**RE: Coronado Village – Water Tank
Grading and Drainage Plan
Stamp Date: 11/21/17
Hydrology File: C18D017**

**RE: CORONADO VILLAGE-WATER TANK
GRADING AND DRAINAGE PLAN
STAMP DATE 11/16/17
HYDROLOGY FILE: C18D017**

NEW STORAGE TANK
GRADING PLAN

ENGINEER'S SEAL 	CORONADO VILLAGE ALBUQUERQUE, NM		DRAWN BY JJG
	NEW STORAGE TANK PLAN		DATE 11/15/2017
	TERRA WEST, LLC 5571 MIDWAY PARK PLACE NE ALBUQUERQUE, NM 87109 (505) 858-3100 www.tierwestllc.com		2014034 UTILITY PLAN-NMED
	SHEET # C1		JOB # 2014034

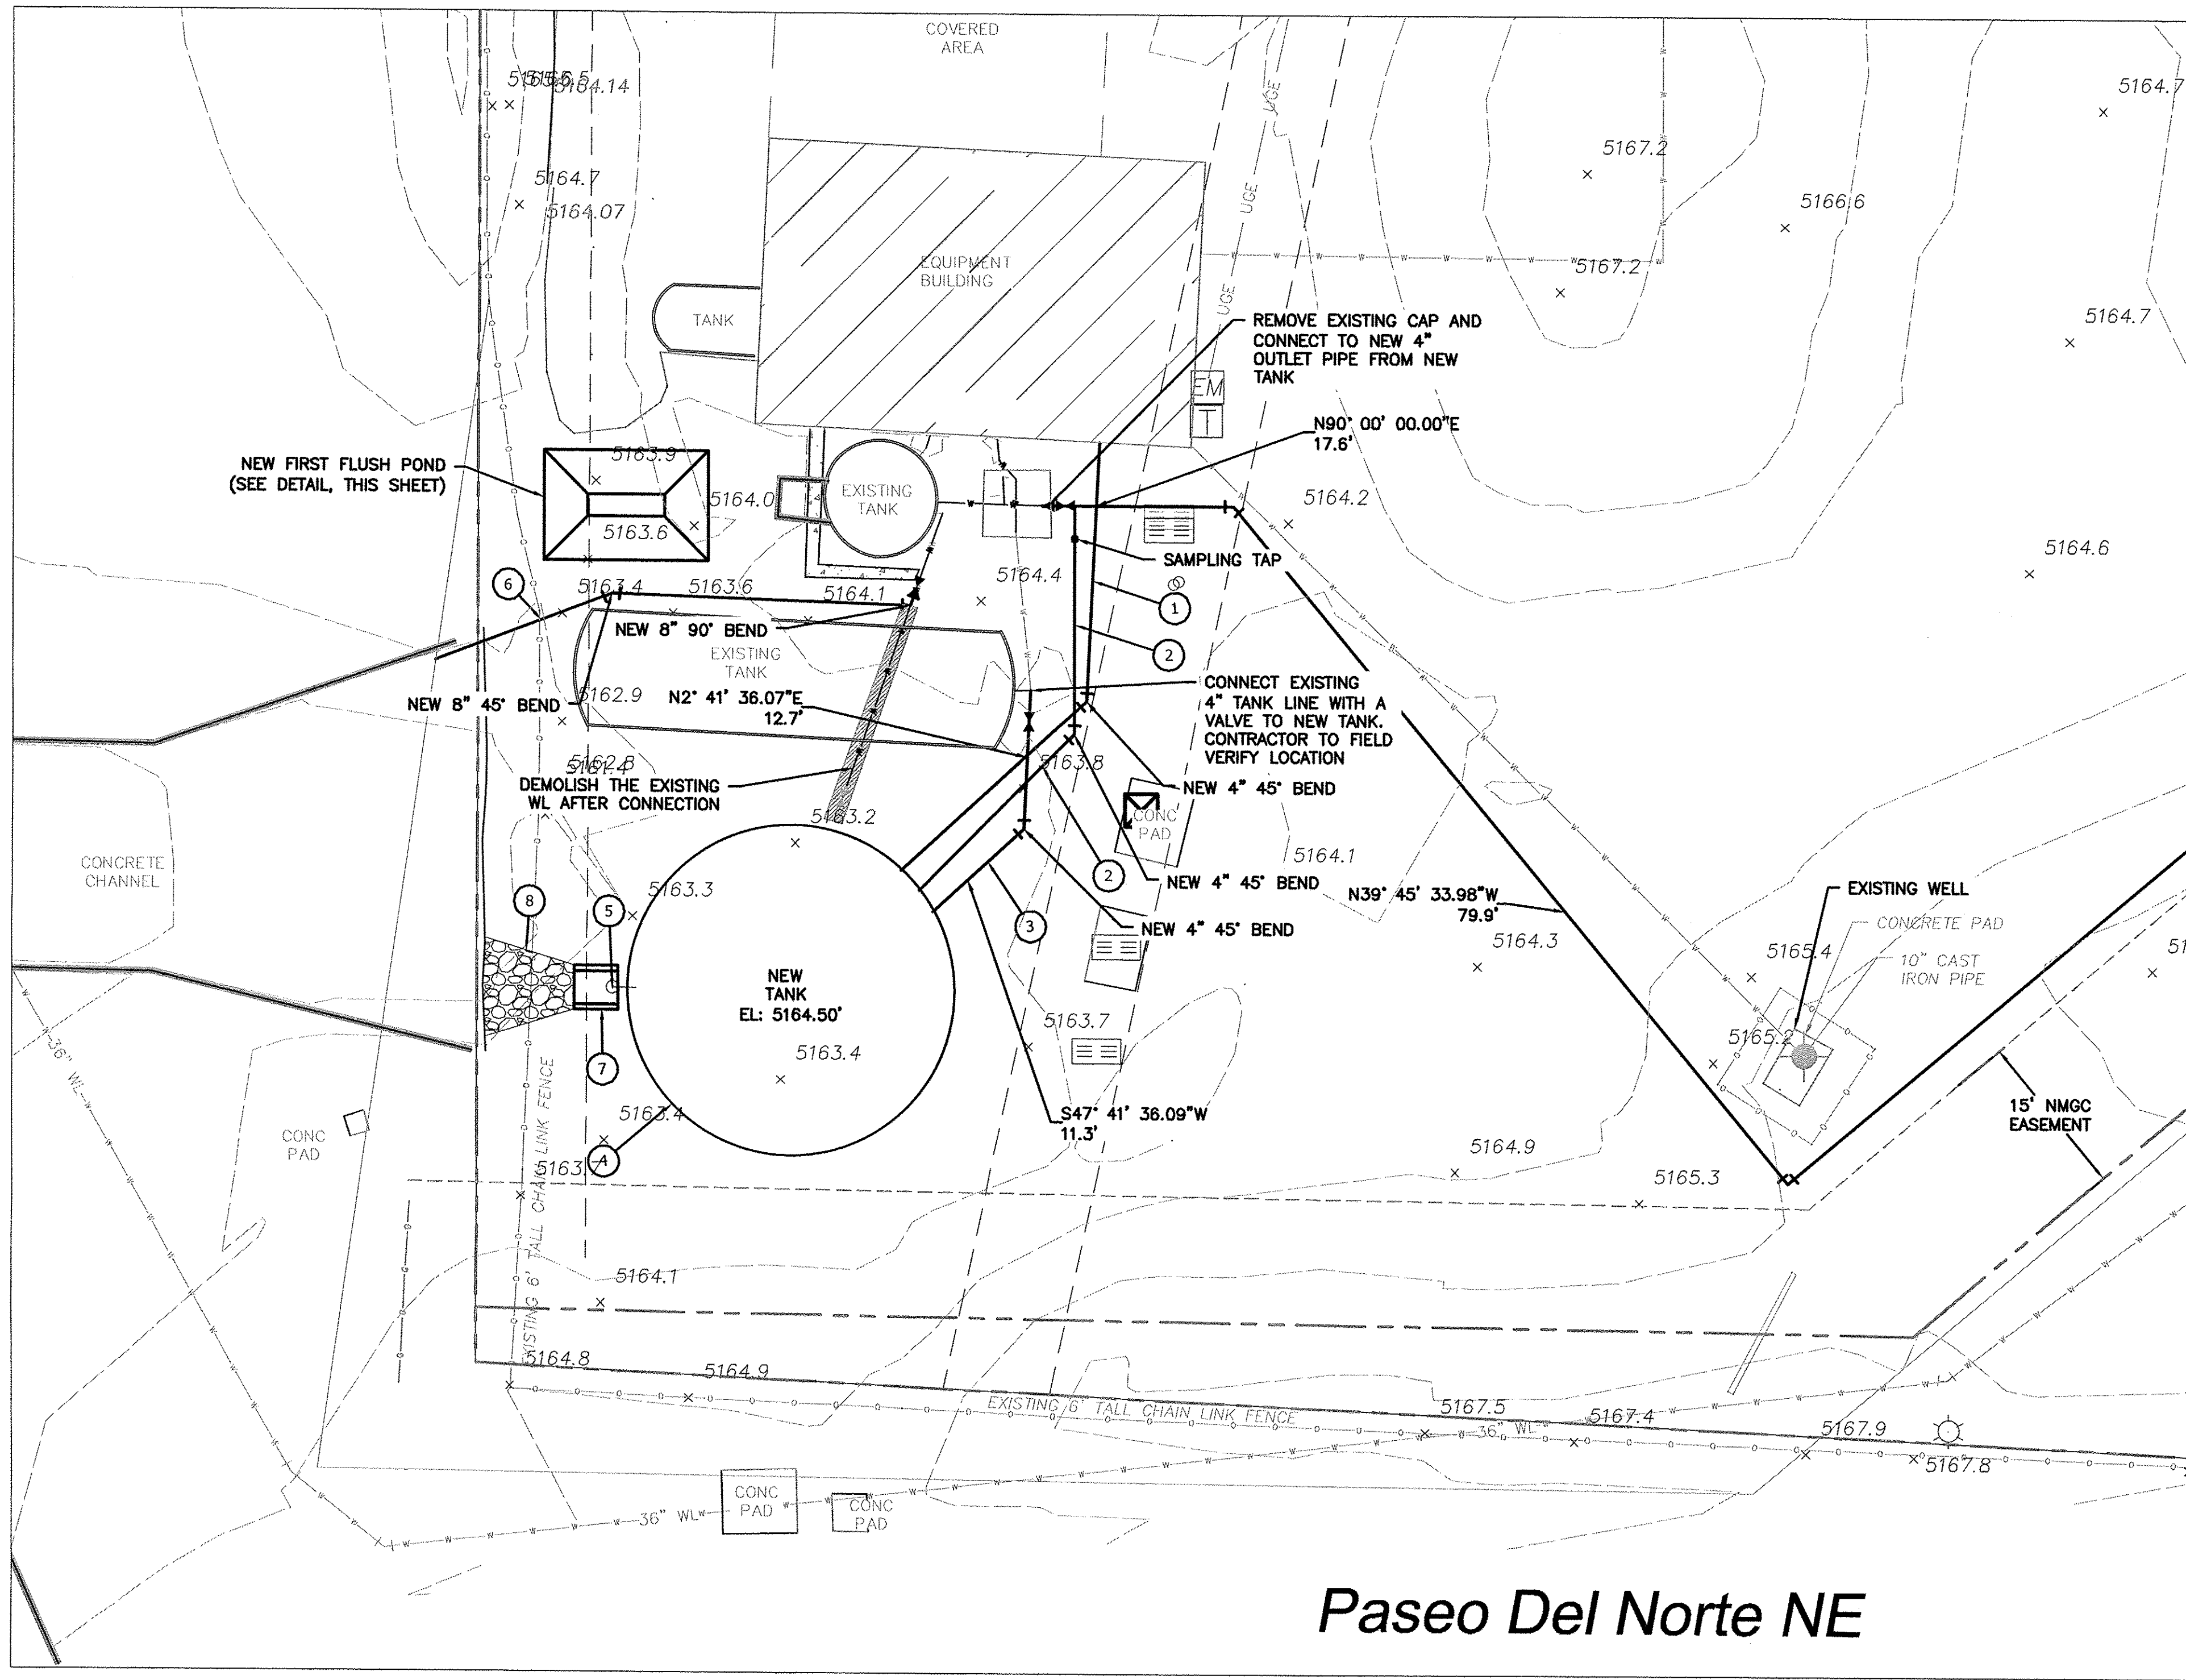
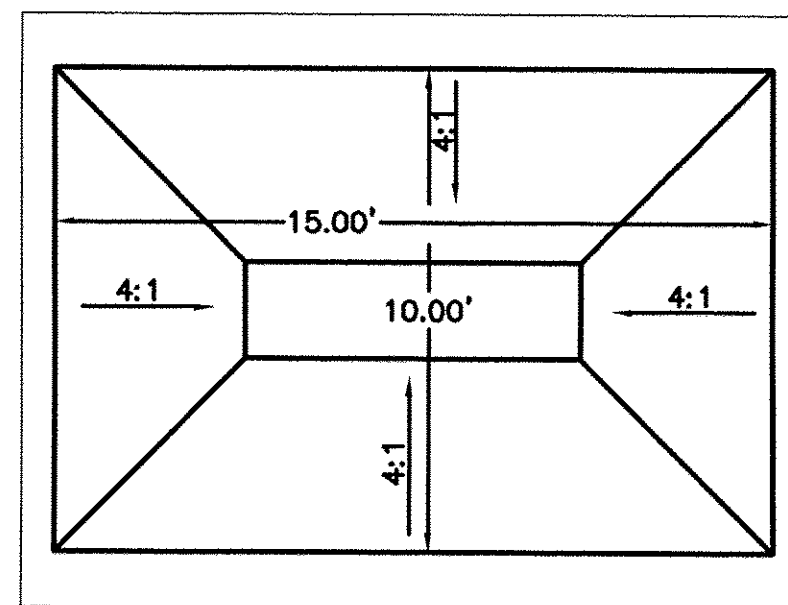
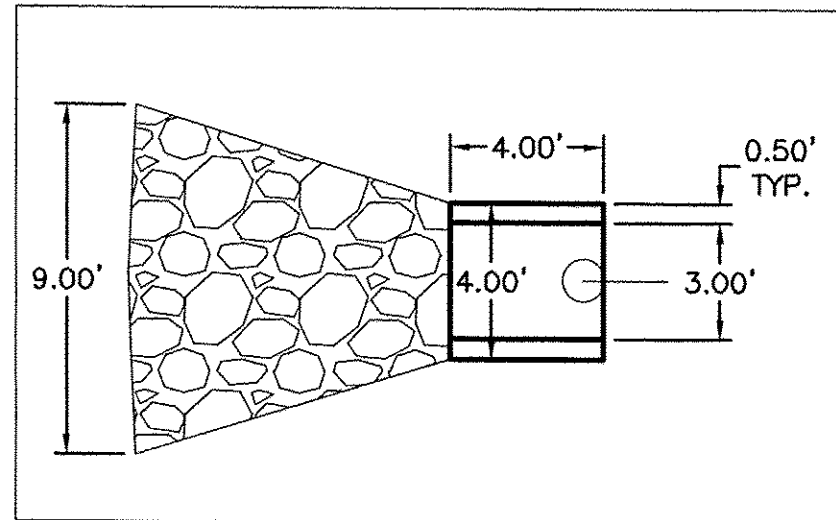
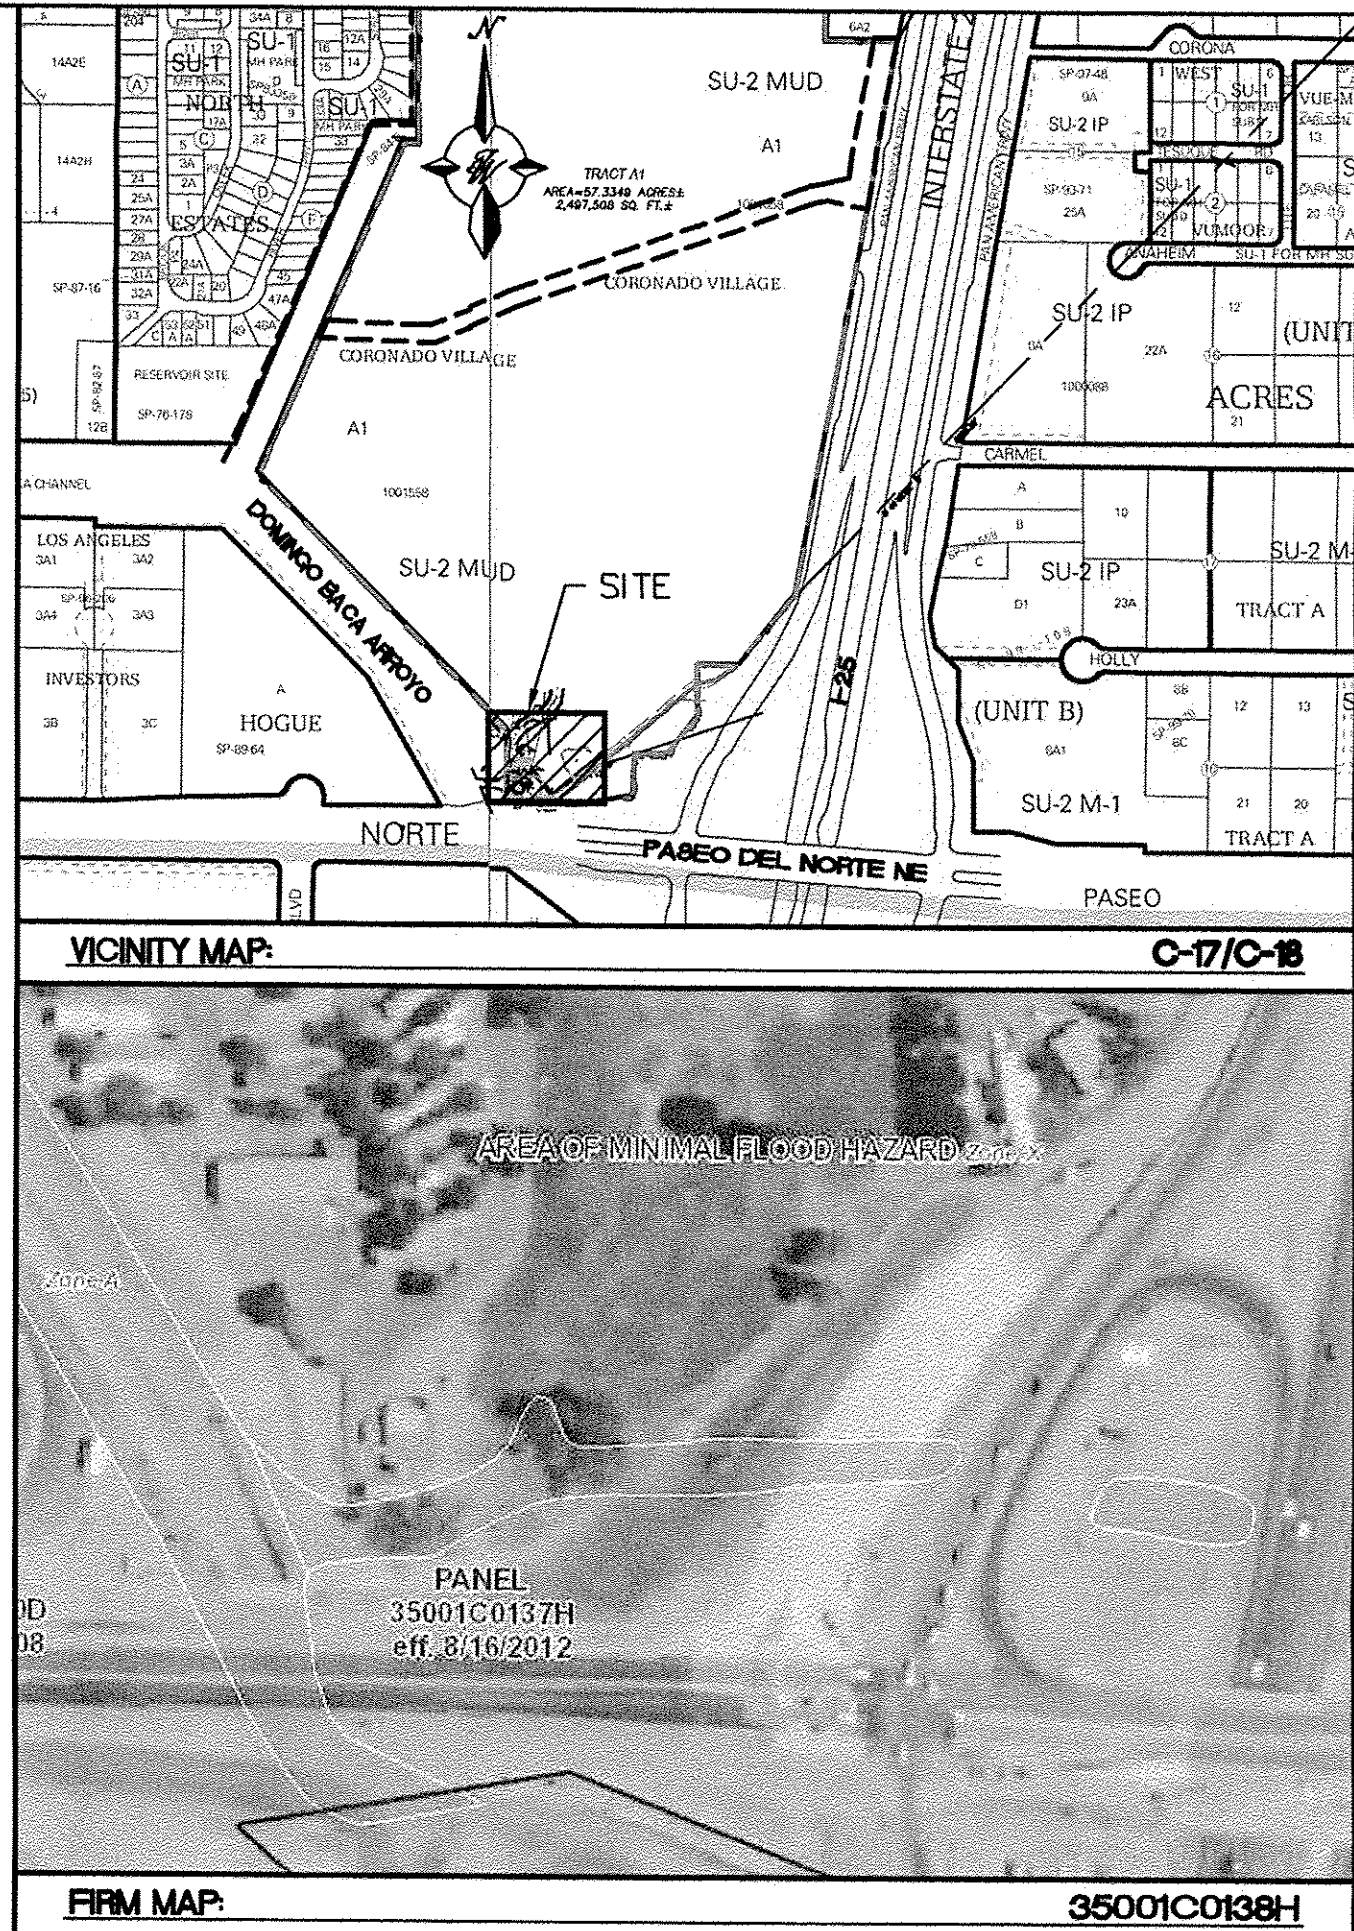
1. Please show and label the flood plain "AO" on the Grading Plan.
The flood plain as it is currently shown on the FIRM map is identified on the Grading Plan

2. Please provide the benchmark information for the survey contour information provided.
The benchmark information is now shown on the Grading Plan.
3. Please relocate the first flush pond. It needs to be directly downslope of the proposed tank so that the runoff goes into it prior to running down the concrete channel rundown to the North Diversion Channel.
We would agree with this statement under normal circumstances, however because this is a water tank the New Mexico Environmental Department will not allow a pond next to the tank. To account for the amount of water that needs to be retained we proposed a first flush pond at the end of the roadway that does drain to the same location as the tank and would retain the same amount of flow that is required.

4. Please either relocate the proposed new tank out of the "AO" flood plain or raise the pad elevation one foot above the 100 year elevation for this "AO" flood plain. This 100 year elevation may have to be calculated.
We have added a Basin Map to the Sheet showing the area that drains to the channel. This area generates a total 100 yr flow of 12.63 cfs. Without the tank in that location that would amount to a depth of 0.19 feet which does not meet the definition of a flood plain. However the tank elevation is one foot above that elevation at that specific location

5. If the location of the proposed new tank is to remain, then please create a diversion swale around the tank to allow the existing runoff flow the concrete channel rundown to the North Diversion Channel and not have the proposed new tank be a blockage for the existing drainage flow.

As mentioned above the amount of flow around the tank is 12.63 cfs. As shown on the cross-section there is room for all of that water to travel around the tank and only obtain a depth of 0.50 feet.
